From: John Baldwinson 
Sent: 22 August 2018 18:05
To: Amber Willard
Subject: Re: AW/184/18/CLP

I am the case officer on your application AW/184/18/CLP at 29 Chawkmare Coppice.

SIDE ELEVATION
PROPOSED ELEVATIONS

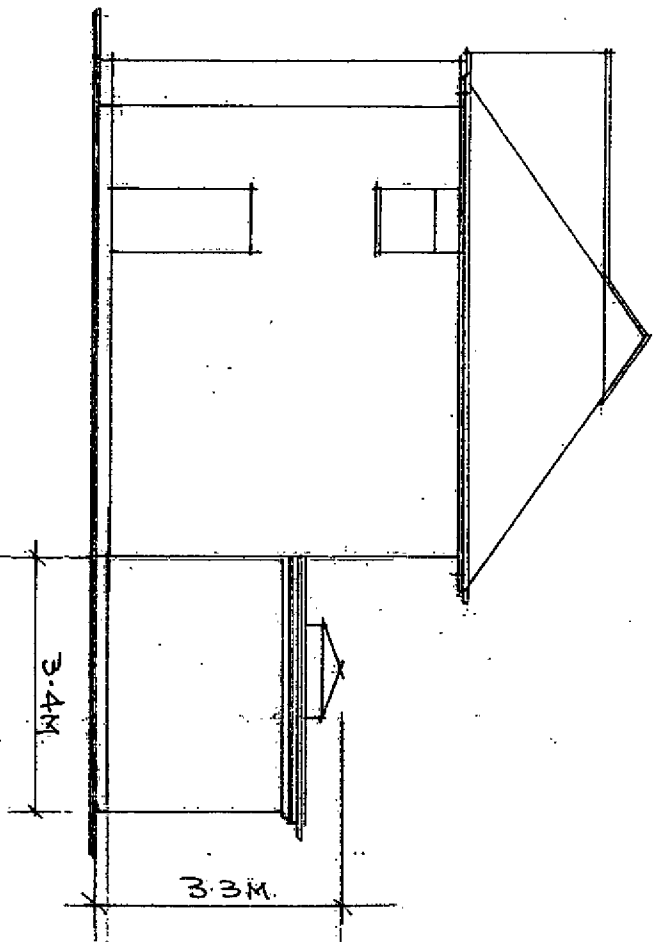
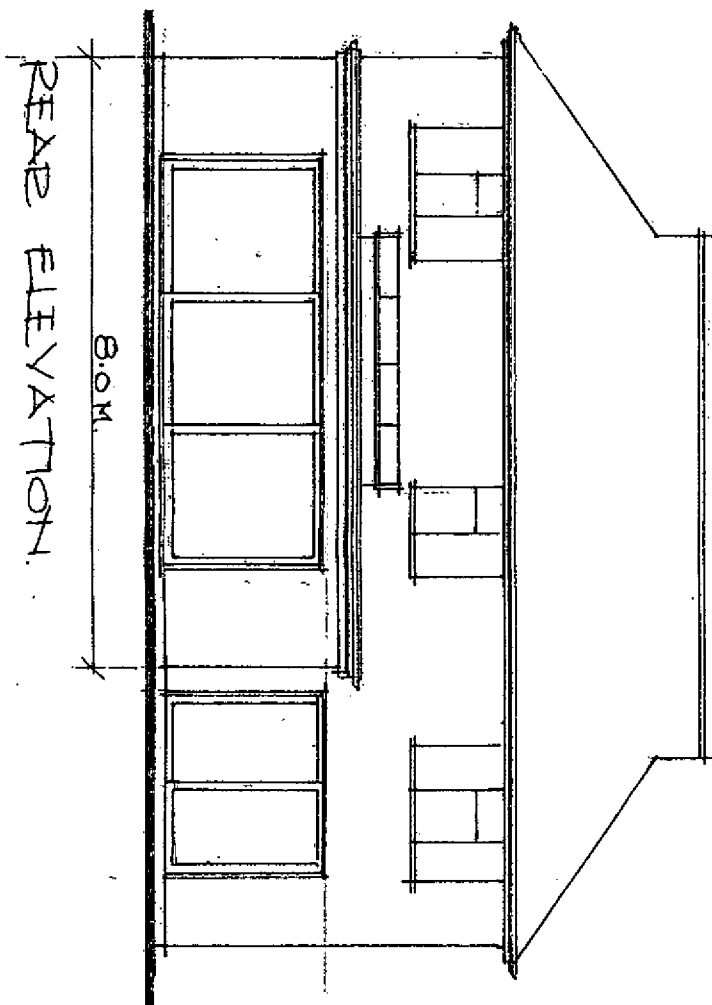
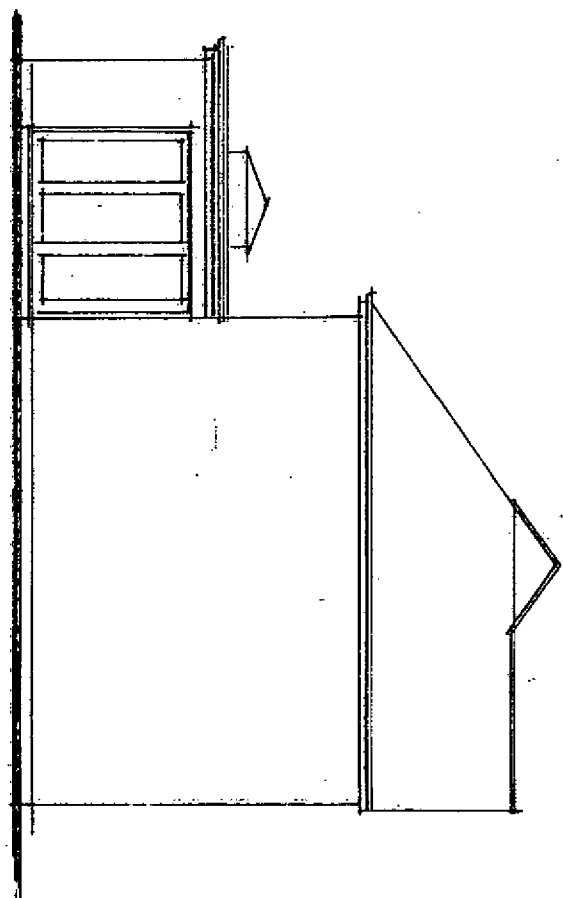
I am writing as I require confirmation that the materials used for the extension will match that of existing dwelling as the materials proposed are not stated in the plans or application form.

Hi I have already emailed confirming that the materials used will match the existing, I hope this is all now ok!
John Baldwinson
